Our Ref: EN010122

Date: 5 March 2024

Application by Oaklands Farm Solar Limited for an Order Granting Development Consent for the Oaklands Farm Solar Park

Advice following issue of decision to accept the application for Examination

Figure 10.5: Location of Sensitive Receptors

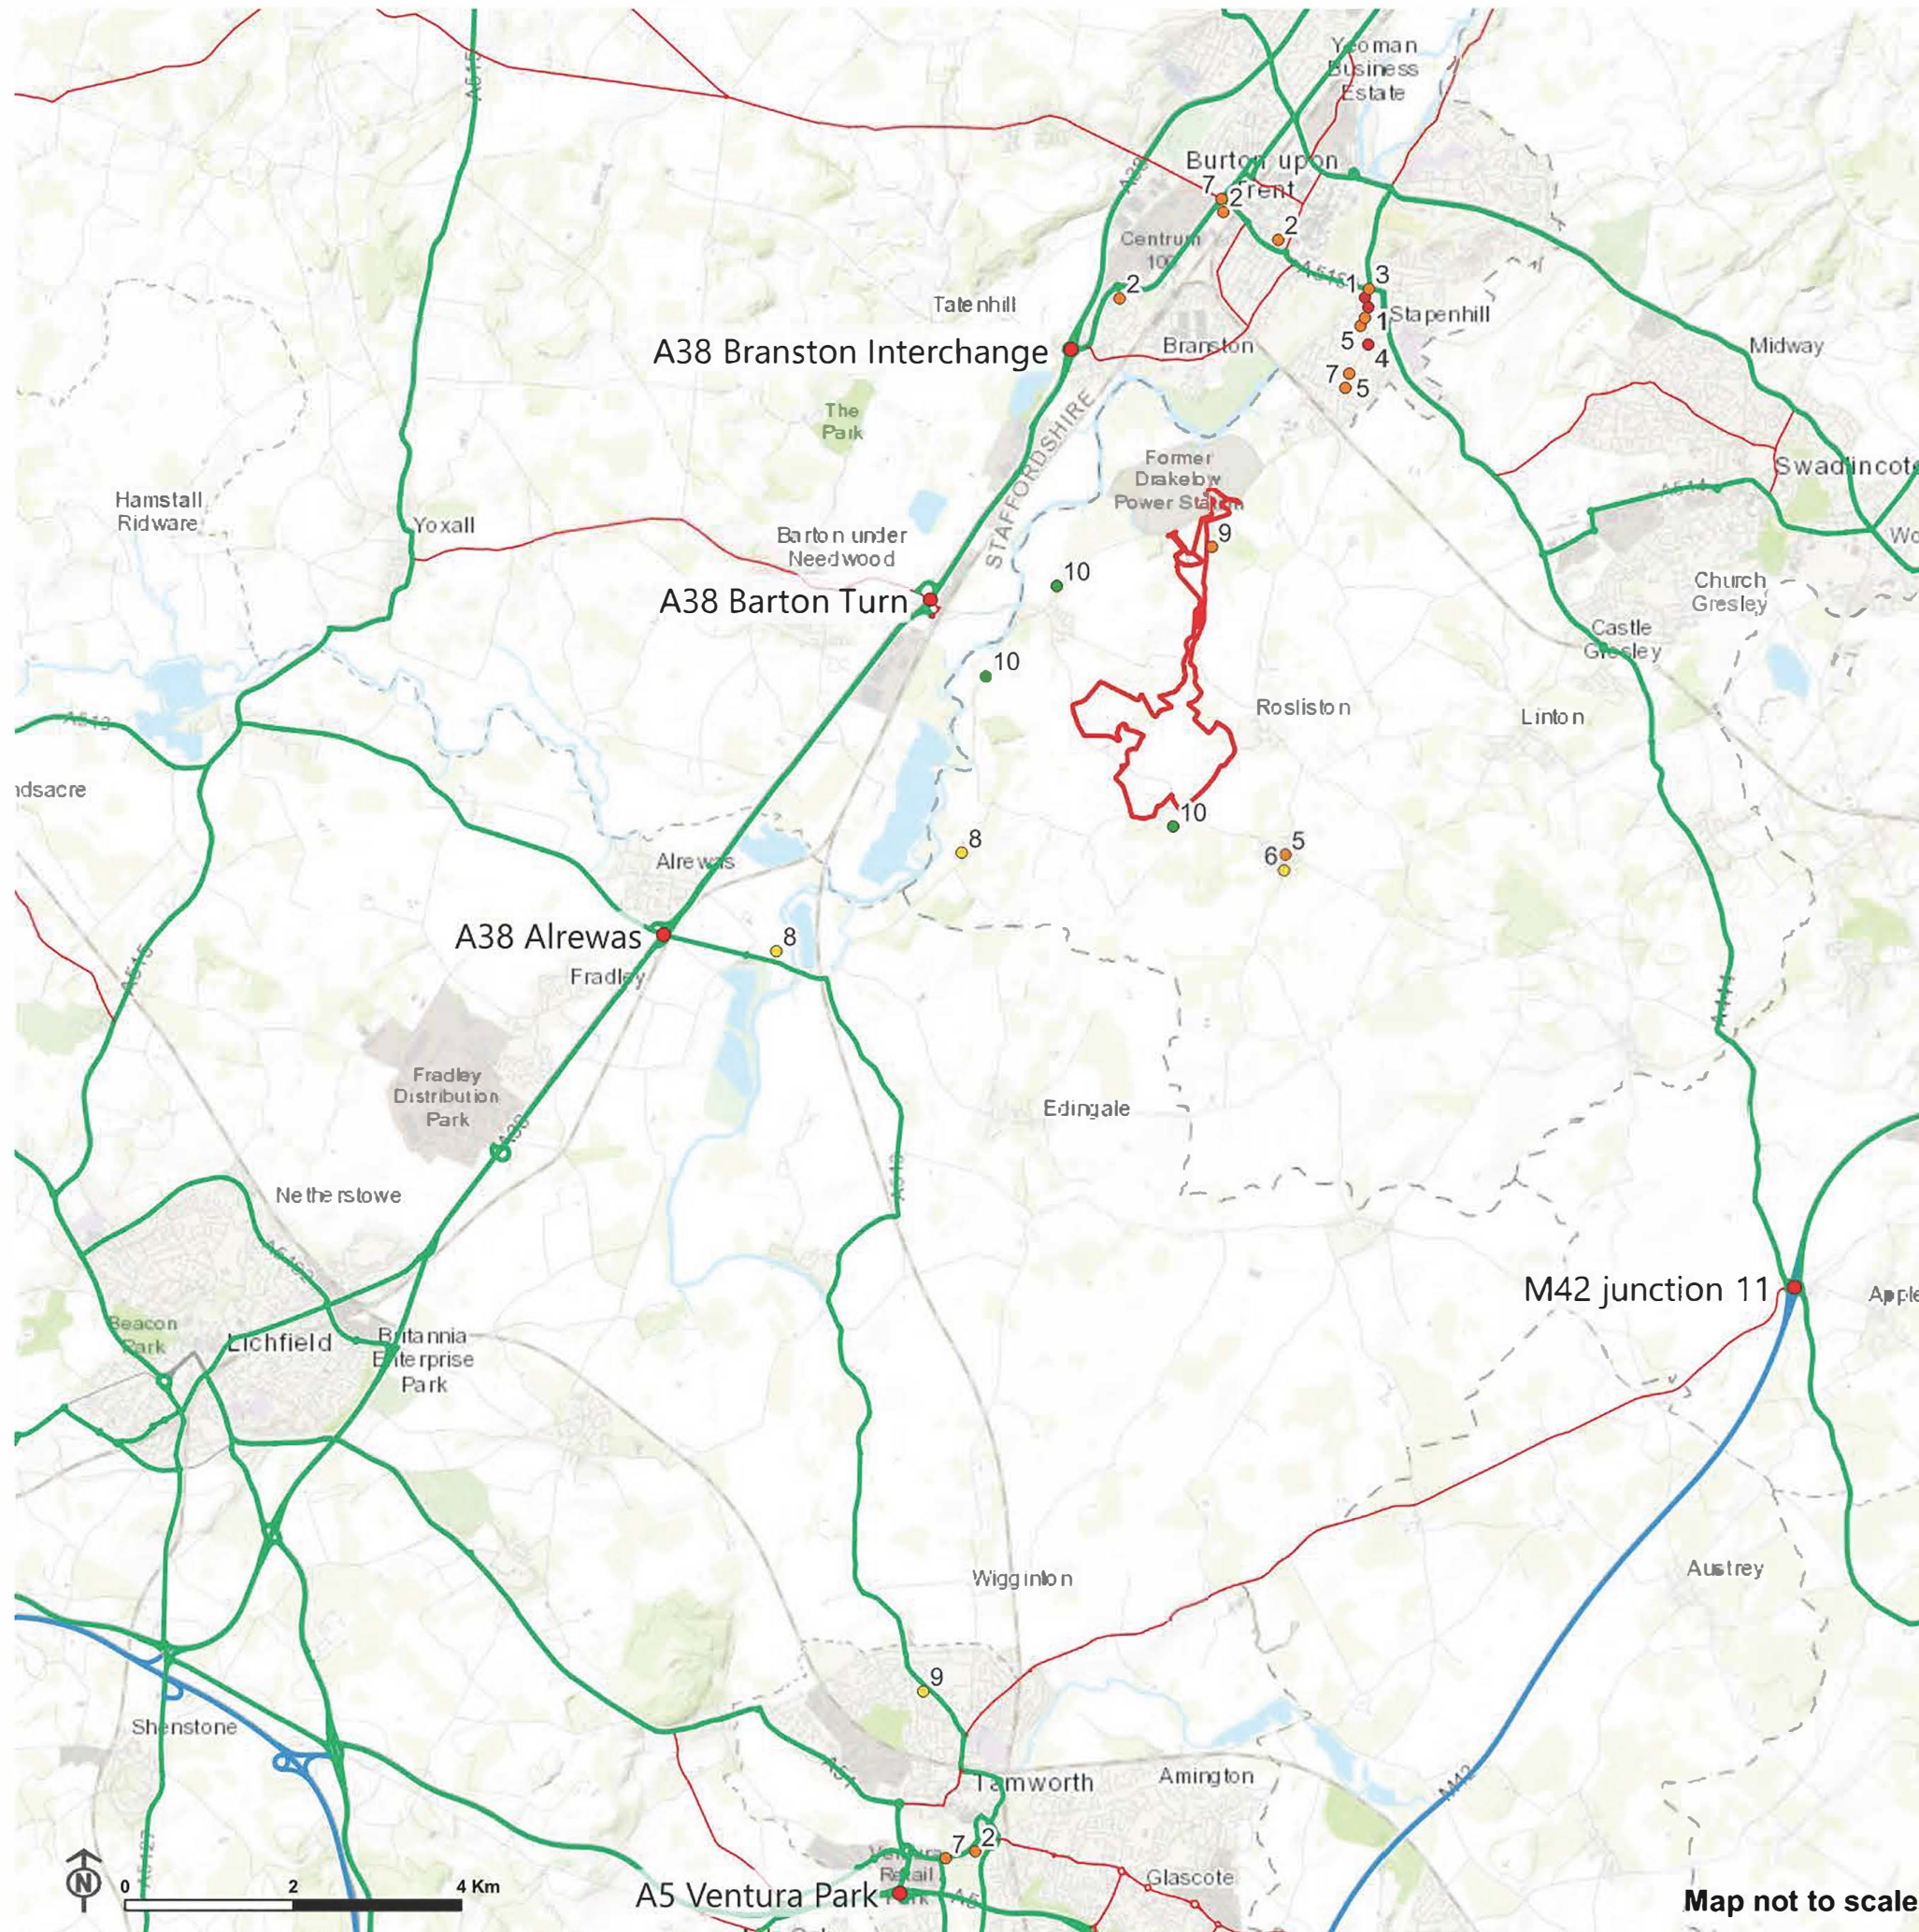
Figure 10.5 only appears to display one of the Air Quality Management Areas (AQMAs) described within ES Chapter 10. The Applicant should provide a figure which clearly depicts both of the AQMAs and their extents.
